**Address: 6 Grafton Street, London, W1S 4EQ,**

**Proposal: Details of waste storage and Operational Management Plan pursuant to conditions 12 and 18 of planning permission dated 23 January 2018 (RN: 17/07355/FULL).**

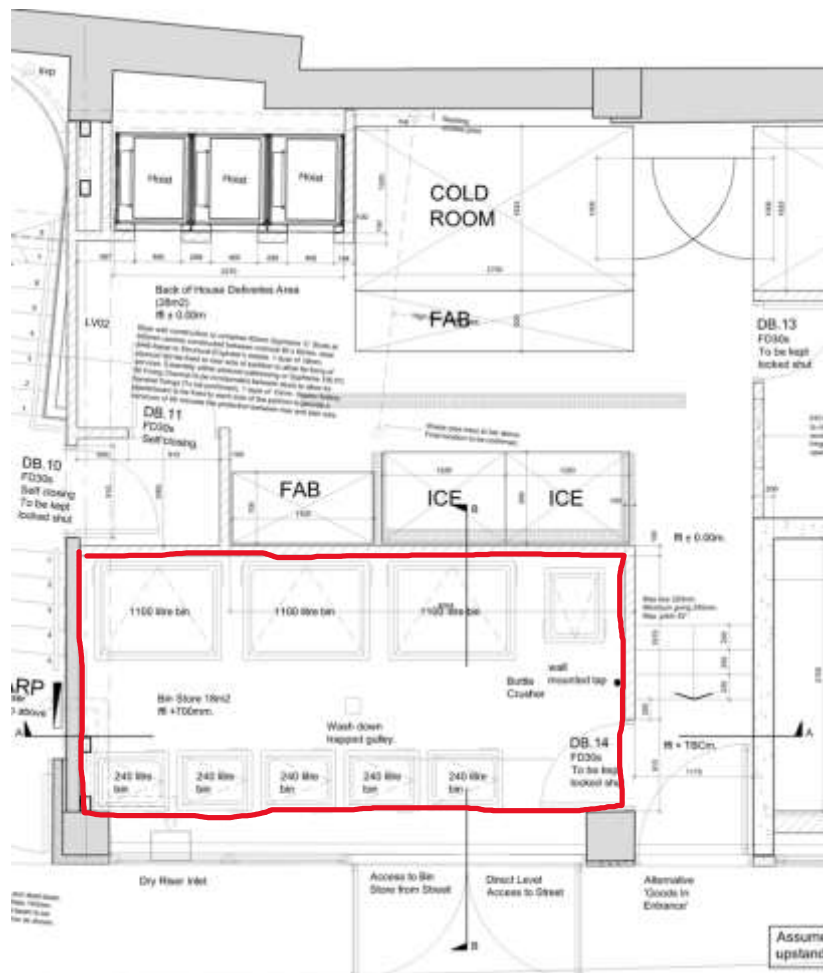
- 1 The waste provision shown in the Operational Management Plan (OMP) shows no more detail than that submitted in the original application. Although a bin store was indicated on the image within the OMP, the waste detail submitted are not in line with the council waste storage requirements. Three to four different waste streams are expected from this development which are food waste, waste cooking oil, general waste, and recyclable materials. The three or four waste streams must be stored separately in different bins. You need to confirm the bin capacity for each waste stream.

The bins should be indicated and labelled O (for food waste), WCO (for waste cooking oil), R (for recycling) and W (for waste) on the drawing. Please refer applicant to the City Council Recycling and Waste Storage Requirements

Please provide a drawing containing the above information.
